Subject: CU-14-00004 McIntosh Small Scale Event Facility  
US 97 milepost 138.89 right

**RE:** CU-14-00004 McIntosh

RE: McIntosh CUP (CU-14-00004)

EXISTING
OUTDOOR ARENA

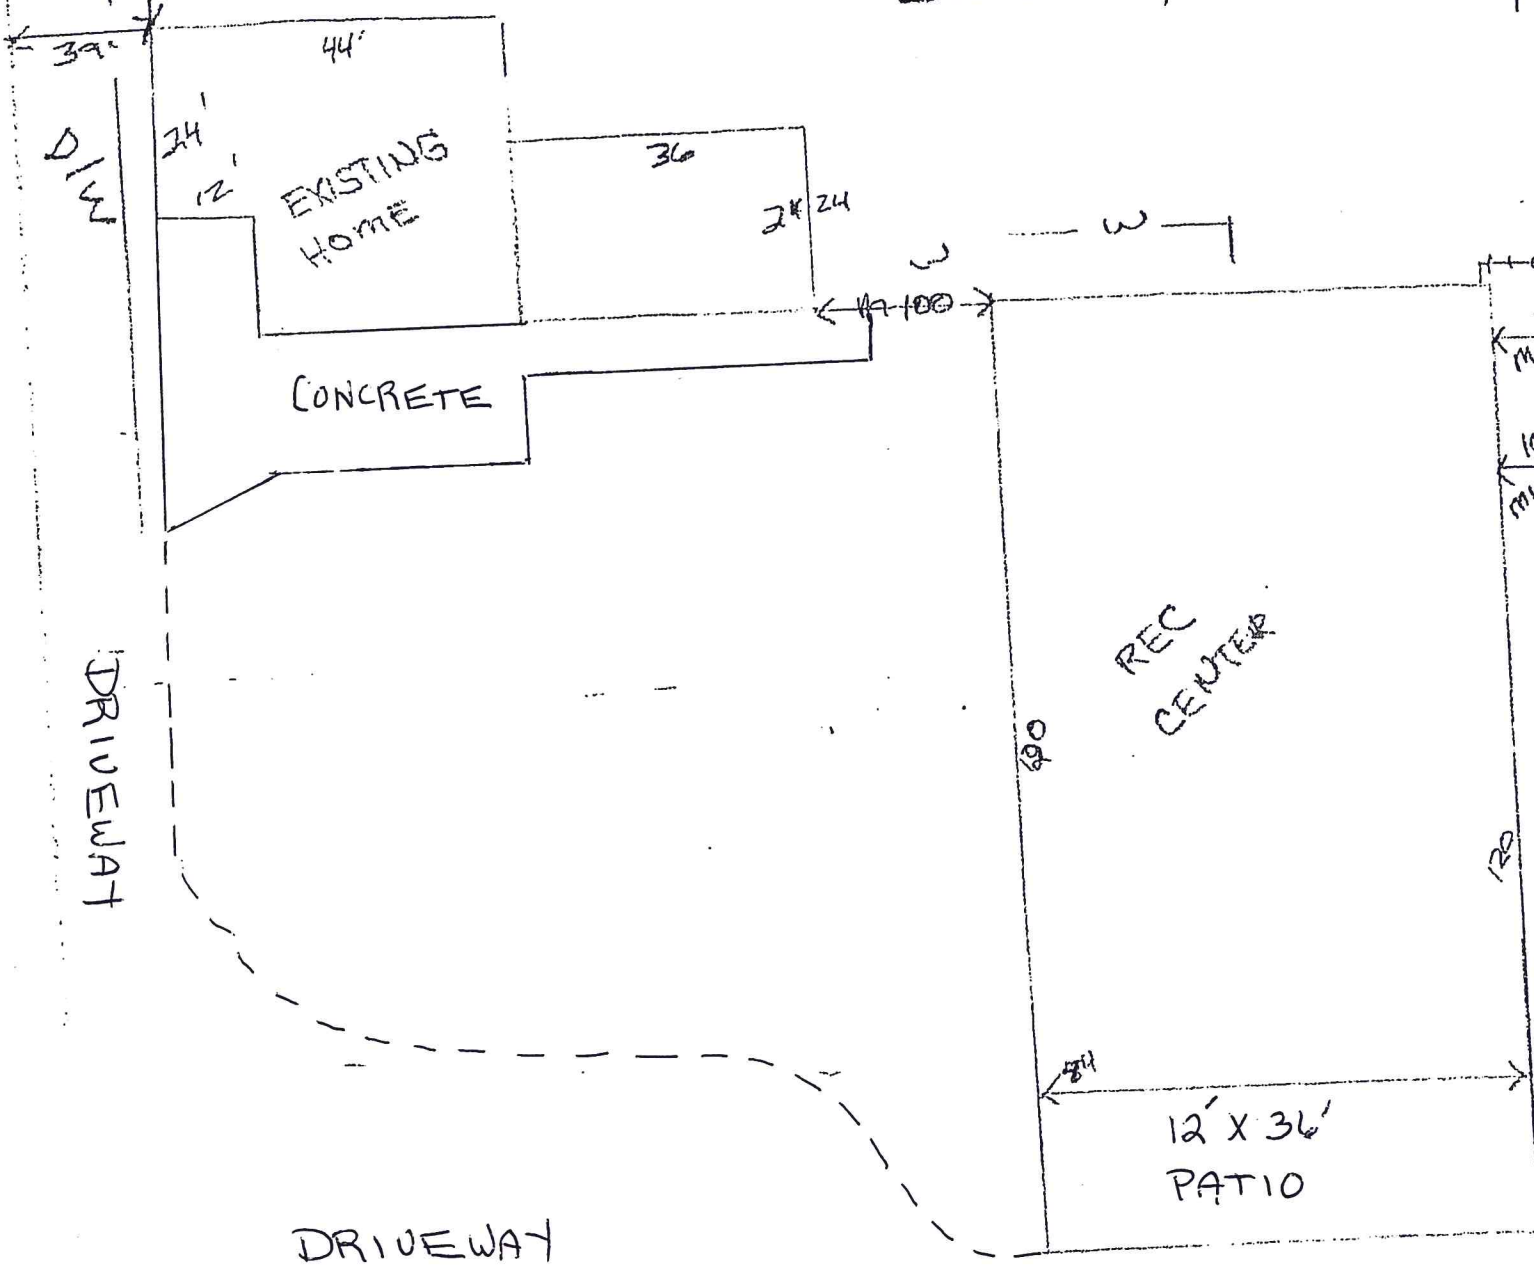
- The County should require the proponent to provide obstruction-free ingress/egress for two-way traffic beyond the approach to prevent vehicles from backing up onto US 97 while entering the facilities during events. WSDOT highly encourages the County to require the use of on-site signage and parking attendants to manage the entering vehicles. If events cause vehicles to back up onto US 97, WSDOT will require the proponent to construct a right turn lane at the proponent's expense.

- Parking will not be permitted within WSDOT right-of-way. Appropriate on-site parking provisions are required during events. The decommissioned roadbed lying parallel to US 97 on the east side of the highway is within WSDOT right-of-way.

- A turn-around shall be provided for fire department access.
- It would be best for any trailer traffic to park in the very back parking lot, with signage indicating parking for trucks/trailers.

- Passenger vehicle parking must be regulated so that emergency vehicles have full access throughout the facility. Signage and/or staffing for events should be provided so that people do not mistakenly park in a fire apparatus access lane.
